DECISION DELEGATED TO HEAD OF PLANNING

Application No: H09-0395-24 **Applicant:** Mr T Penny

Proposal: Proposed conversion of barn into residential dwelling - approved under H09-0701-23. Modification of Condition 2 to allow amendments to previously approved plans

Location: Rear Of 58 Spalding Road Holbeach Spalding

Elevation 03 - Rear
1 : 100

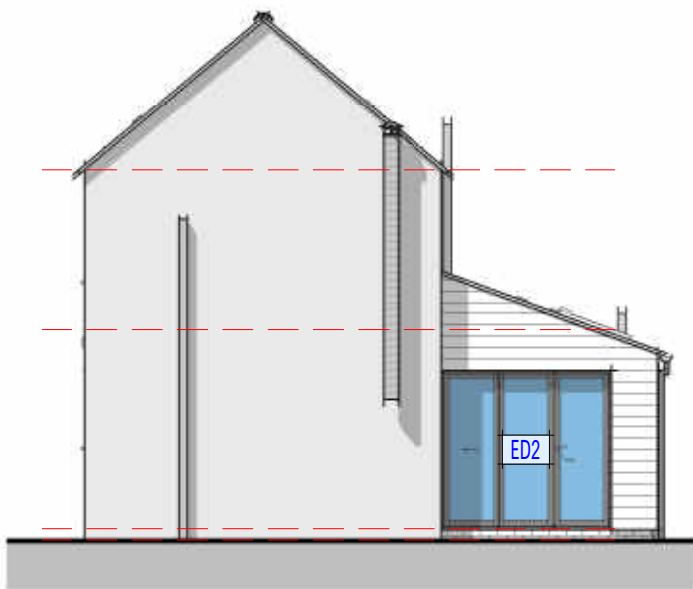
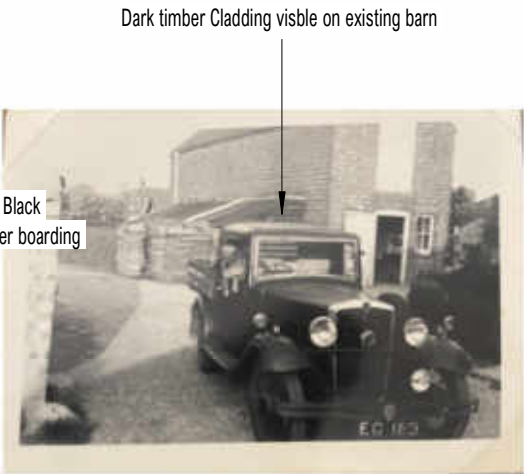
The first floor windows on the rear elevation facing 4, 6 and 8 Fairfields are associated with a bathroom and landing. The approved plans (ref. H09-0701-23) indicate that they would be obscure glazed (at least level 3) with top opening lights only. However, side hung obscure glazed windows have been installed that fully open, overlooking the neighbouring gardens at close range.

The submitted plans accompanying this application indicate that obscure glazed (at least level 3) bottom opening sashes will be installed with 100mm restrictors. However, no specification or sections of the windows have been submitted to clearly demonstrate that there would be no material overlooking of the neighbouring properties to the north. Consequently, the submitted plans/details do not meet the required tests of precision and enforceability due to this deficiency. To grant planning permission on that basis would risk unacceptable planning harm to the amenity of nearby residents.

Regarding amenity, the submitted plans accompanying this application indicate that obscure glazed (at least level 3) bottom opening sashes with 100mm restrictors will be installed on the rear elevation at first floor level. However, no specification or sections of the windows have been submitted to demonstrate that there would be no material overlooking of the neighbouring properties to the north. Consequently, the submitted plans/details do not meet the required tests of precision and enforceability due to this deficiency. To grant planning permission on that basis would risk unacceptable planning harm to the amenity of nearby residents.
